07 May 2012

Ms Rebecca Newman
Senior Planning Officer
Infrastructure Projects
Department of Planning and Infrastructure
G.P.O. Box 39
SYDNEY NSW 2001

Re: Exhibition of Environmental Assessment for Port Waratah Coal Services Terminal 4 Project (MP10_0215) .

Future site access plan showing proposed intersection improvements

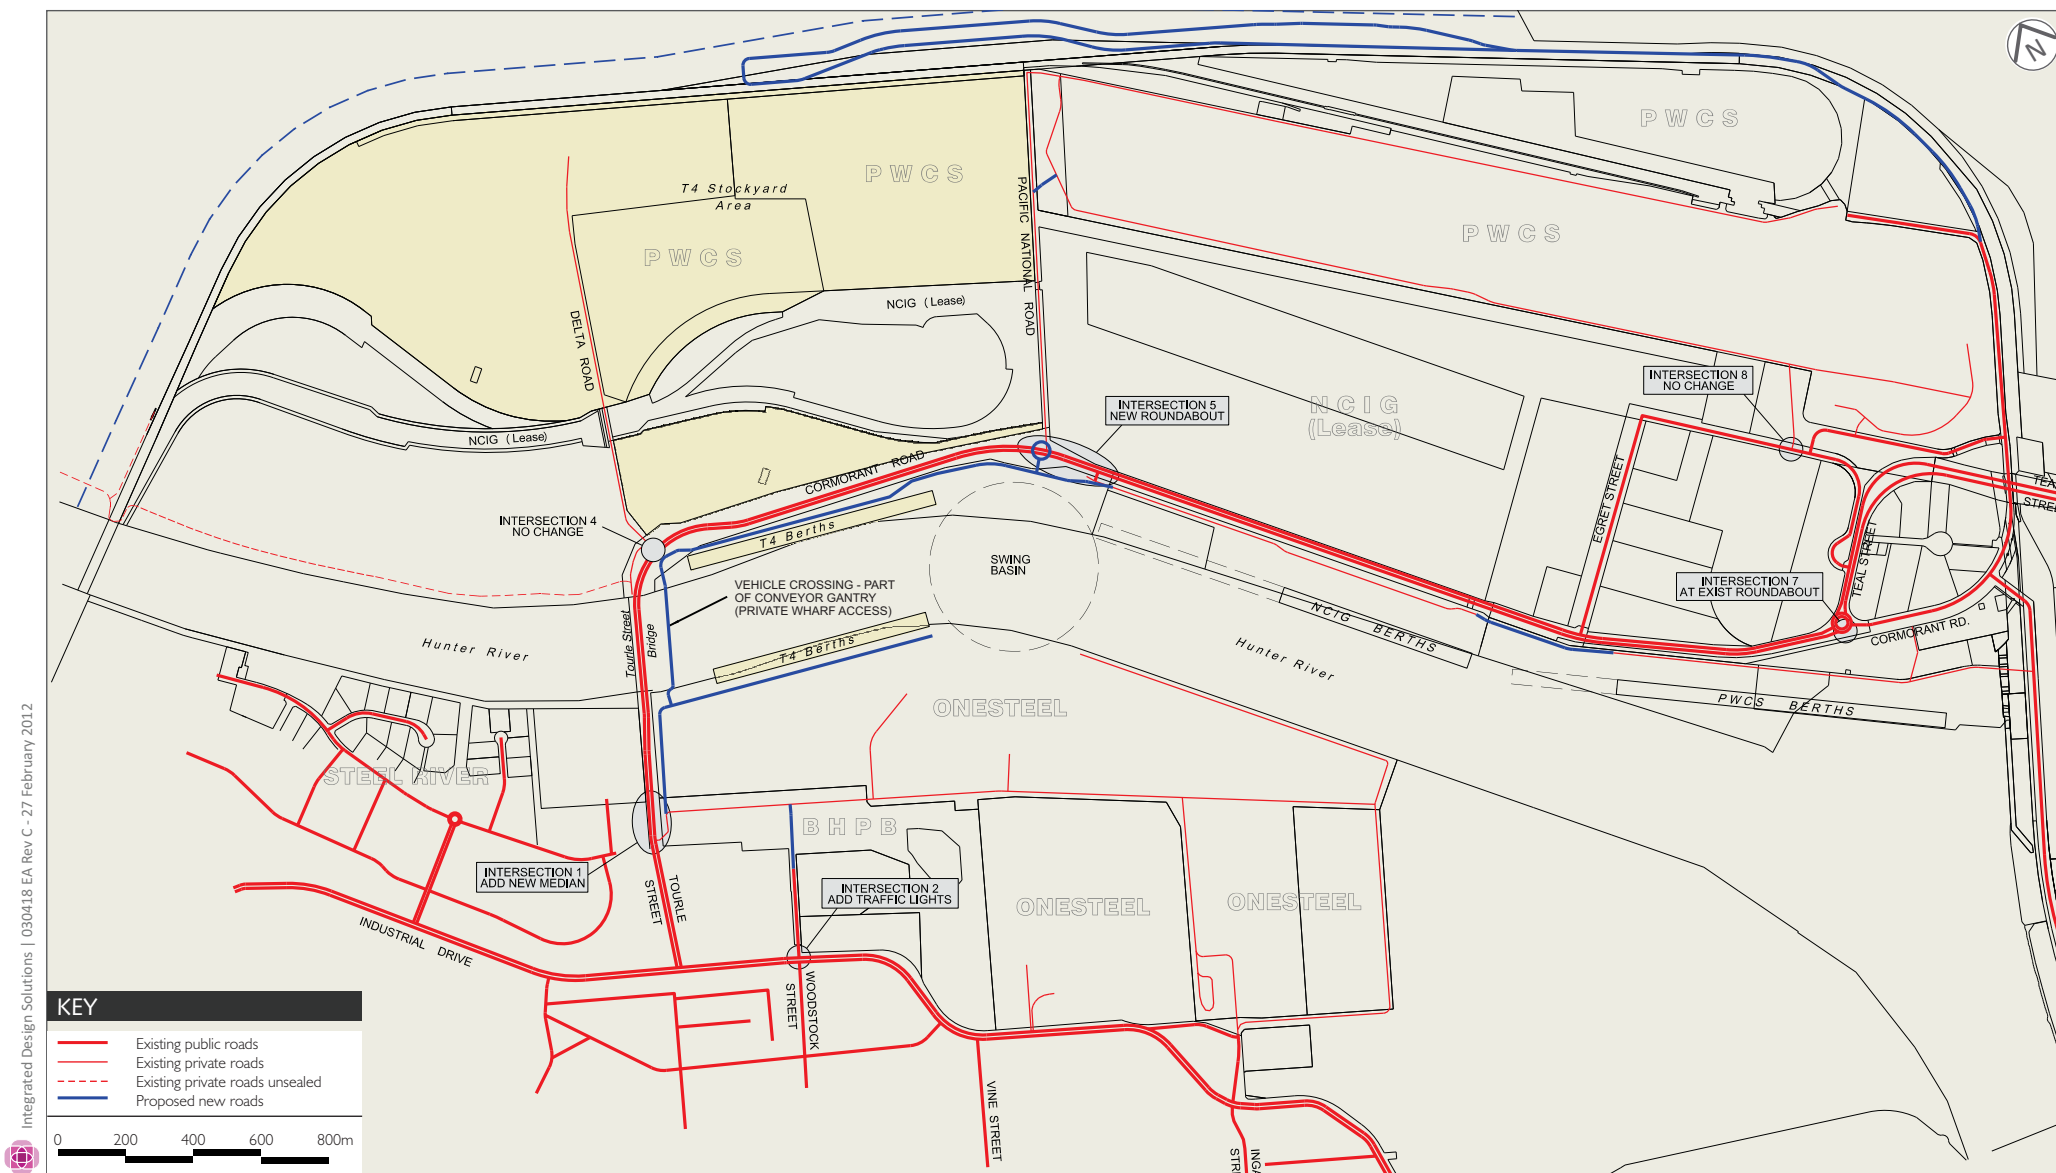
Vehicular access to the southern bank wharf area is dependant on the proponent obtaining the agreement of a number of different land owners. These agreements will in turn determine the access location onto Industrial Drive, either Woodstock Street or an alternate location to the east. These agreements should be obtained prior to determination of this application and the location of the access to industrial Drive confirmed and modelled to determine adequacy.

In this regard, concern is raised in relation to the close proximity of any proposed traffic signals at Woodstock Street to the signals at the Industrial Drive / Tourle Street intersection. Traffic modelling should be undertaken to determine that these signals would function without adversely impacting on Industrial Drive.

The longitudinal grade of the northern leg of Woodstock Street on approach to Industrial Drive is not considered desirable for heavy vehicle activity. It is therefore recommended that the proponent investigate the option of accessing the southern bank wharf area via Vine Street or alternatively Ingall Street.

Notwithstanding the above, should traffic signals be installed at Woodstock Street it is recommended that it only operate as a traffic signal controlled T- intersection with the southern arm of Woodstock Street being closed to all traffic to protect residential amenity. Any such road closure would require community consultation.

A roundabout or traffic signals are proposed on Cormorant Drive linking the Pacific National Road and a realigned NCIG access road.

It is recommended subject to RMS concurrence that traffic signals be installed to maximise road safety while permitting greater flexibility to respond to fluctuations in traffic volumes at different times through the variation of signal phasing ('green time').

The RMS are proposing to extend the Tourle Street approach to left turn slip lane into Industrial Drive resulting in the entrance to this lane coinciding with the proposed entry/exit to the southern bank wharf area. Concern is raised in relation to potential for rear end accidents and therefore it is considered that this access either be deleted or restricted to left out only. Further discussions will be required with RMS in relation to this matter.

The proposed central median in Tourle Street to restrict vehicular access is supported, although the length of this median will be required to be sufficient to deter U-turn movements. The length of this median would be determined in consultation with RMS and NCC at the detailed design stage. This median should be constructed prior to operation of the Tourle Street access.
